KIRKLEES METROPOLITAN COUNCIL INVESTMENT & REGENERATION SERVICE

Reference No:	2026/44/90693/W
Site Address:	Land at, Greenhill Bank Road, New Mill, Holmfirth, HD9 1ER
Description:	Discharge of details reserved by Condition 7. (highway safety) of permission 2023/90346 for erection of two detached dwellings
Recommending Officer:	Sarah Longbottom

DECISION – Discharge of Condition - Refused

Application Ref: 2026/90693

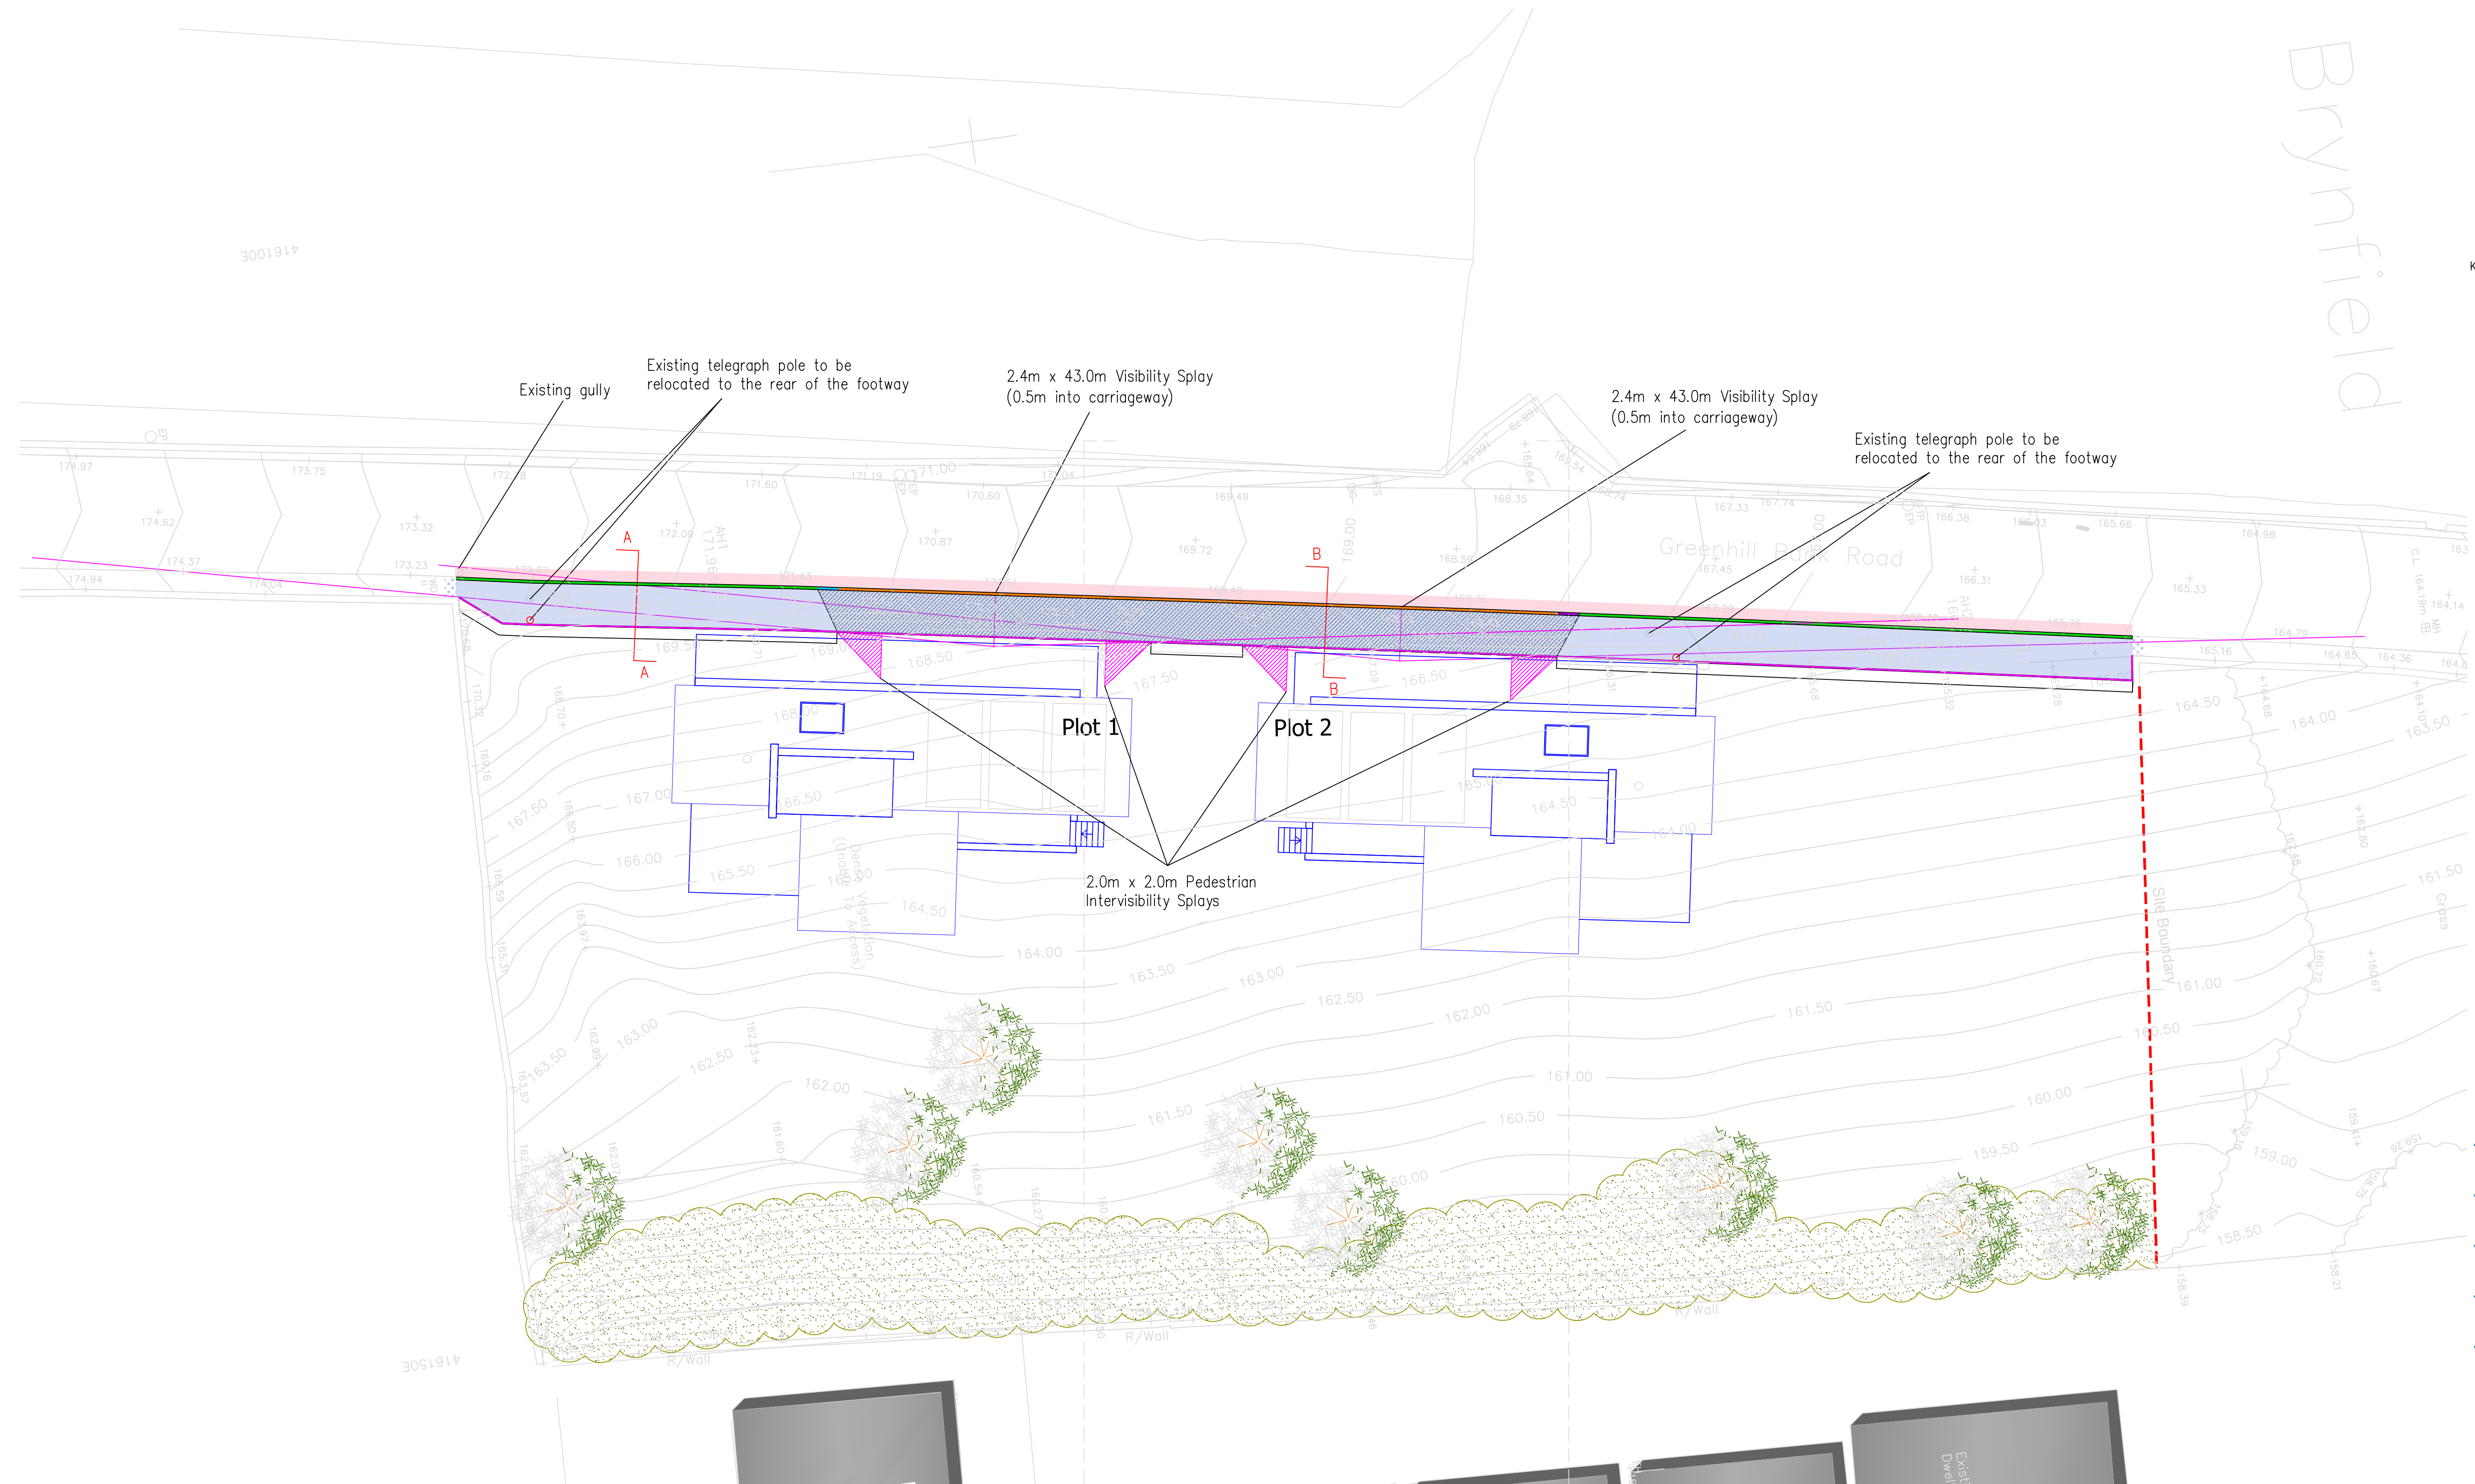
The applicant has provided details showing the 2m footway along the frontage of the site, details of kerbing and construction and surfacing, details of the relocation of telegraph poles, a swept path analysis showing access to the parking spaces is achievable and 2.4m x 43m visibility splays can be achieved. However, KC Highways DM have confirmed that an independent Stage 1 Road Safety Audit (RSA) still needs to be submitted.

Without the stage 1 RSA, KC Highways DM cannot support the discharge of Condition 7. As such, refusal is recommended.
